DEVELOPMENT REVIEW BOARD
SUPPLEMENTAL SUBMITTAL

PROJECT NO. PR-2021-005459
Application No. SD-2021-00163 SI-2021-01248

September 24, 2021

**RE: PR-2021-005459 RESPONSE TO DRB COMMENTS
LOT 1A BLOCK 2 & LOT 2-A-1 BLOCK 2 SUNPORT PARK
2900 TRANSPORT ST NE**

BUILDING 400 SOUTH ELEVATION

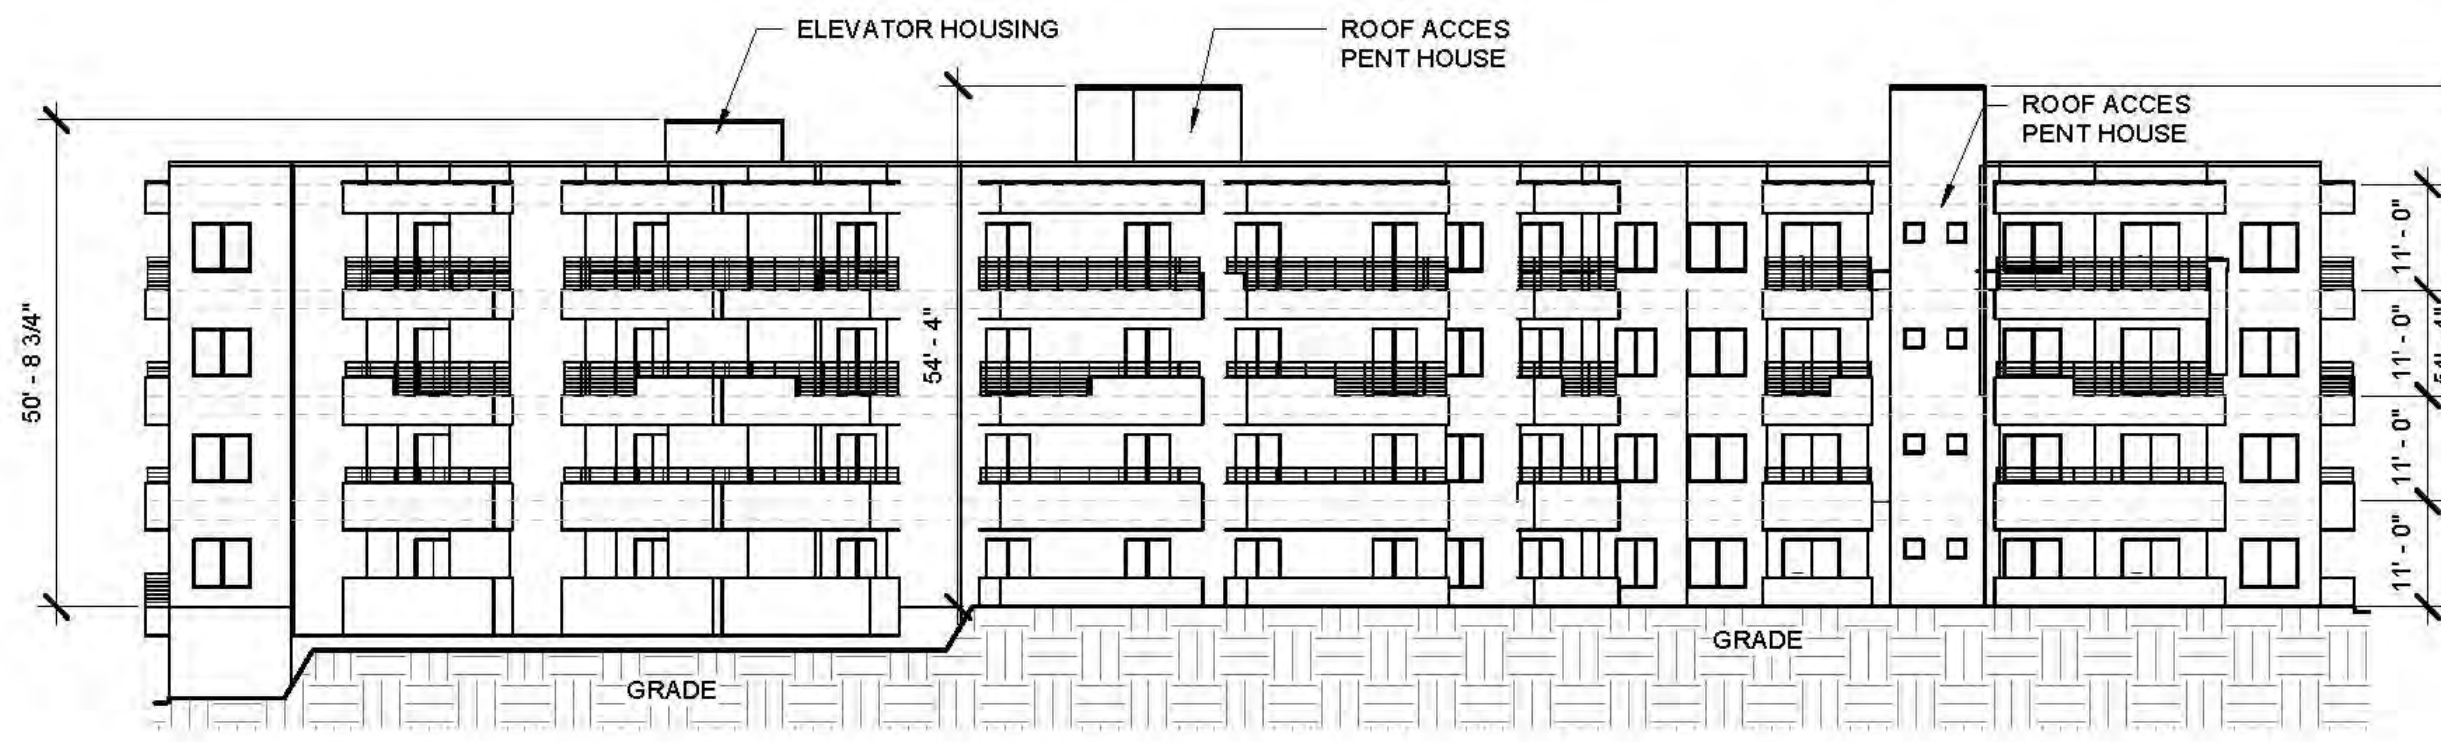
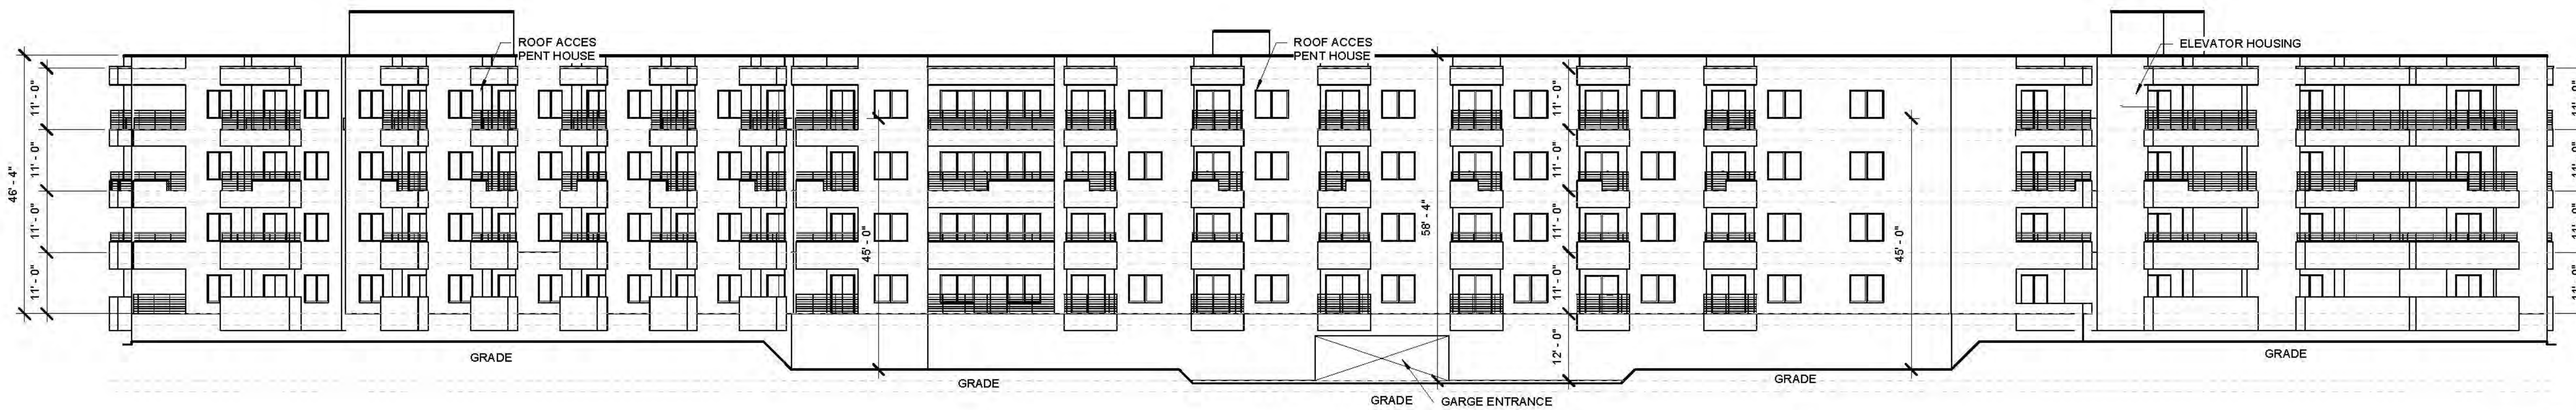
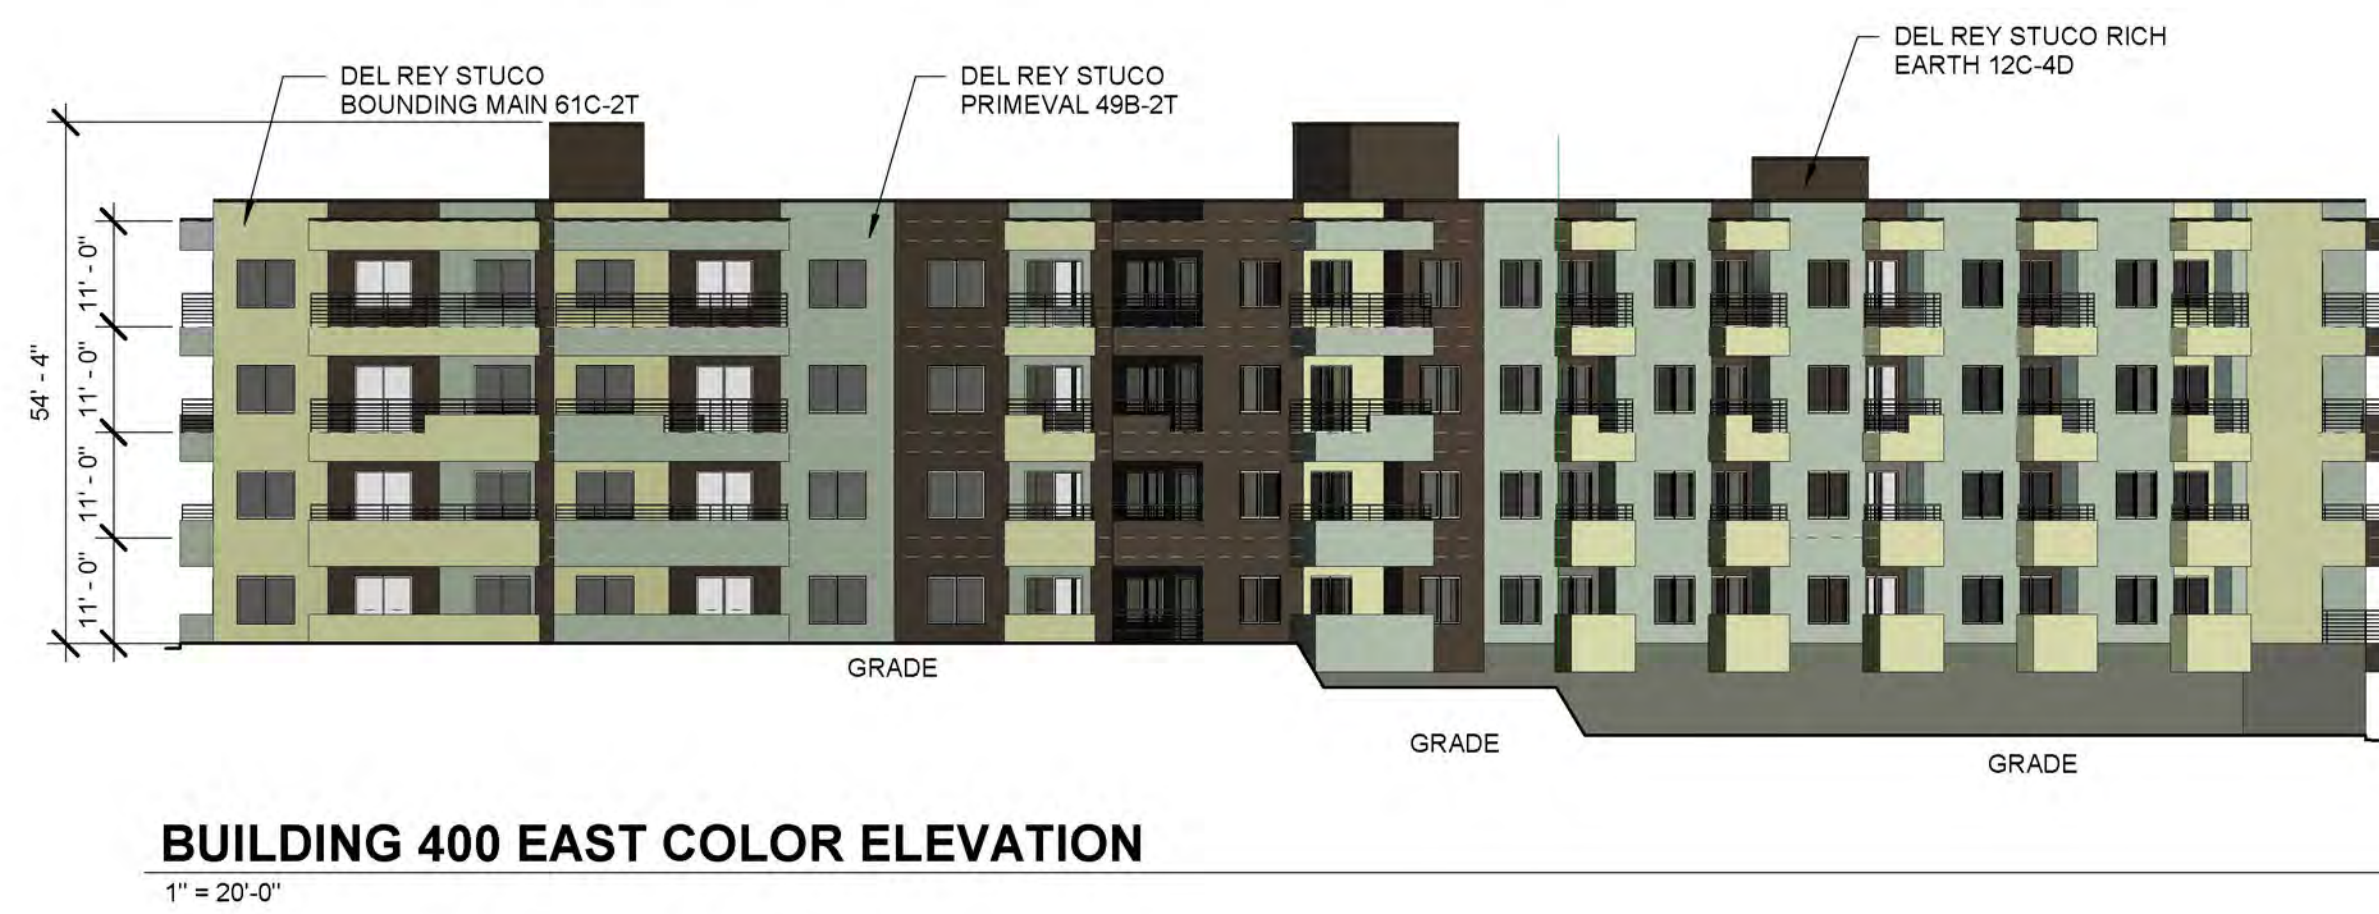
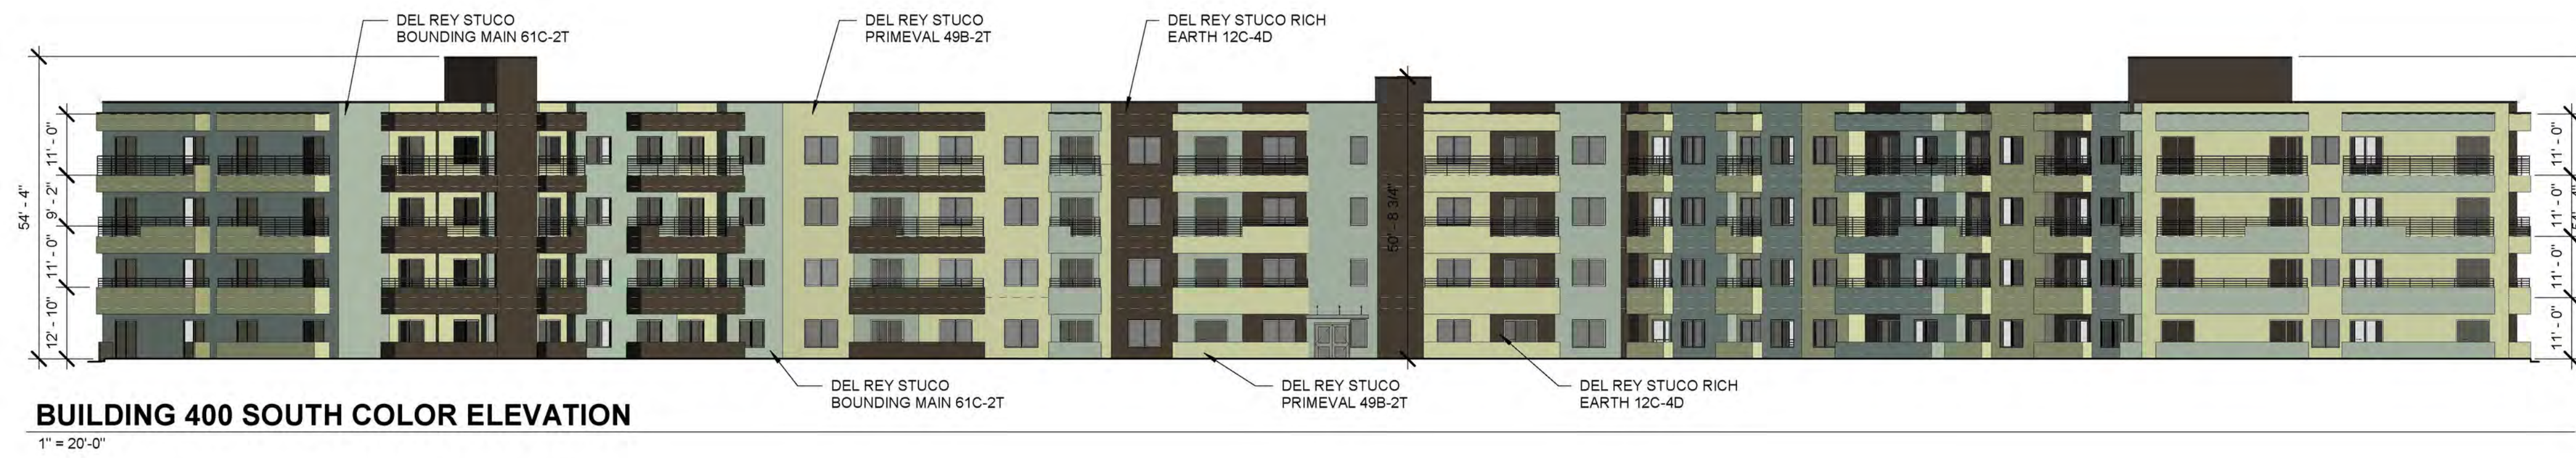
11. The applicant must confirm that the Façade Design requirements of 5-11(D) of the 2020 IDO are being met in a comment response letter and how they are being met. Please note requirement 5-11(D)(1) requiring that entrances be emphasized and provide weather protection. Also, note 5-11(D)(2)(a) Windows requiring heat mitigation features for western windows and recessed or framed windows. Please also note: 5-11(D)(2)(b)(4) Articulation requiring that balcony massing, material, or color shall vary to create visual interest.

RESPONSE: Shade awning callouts added to building elevations, most entrances to the units are off of breezeways. Note added to building elevations to recess windows 2", shade awnings provided at windows on upper floors. Balconies provide shade to glazing below them. Balconies vary in massing and material, reference building elevations included in this resubmittal.
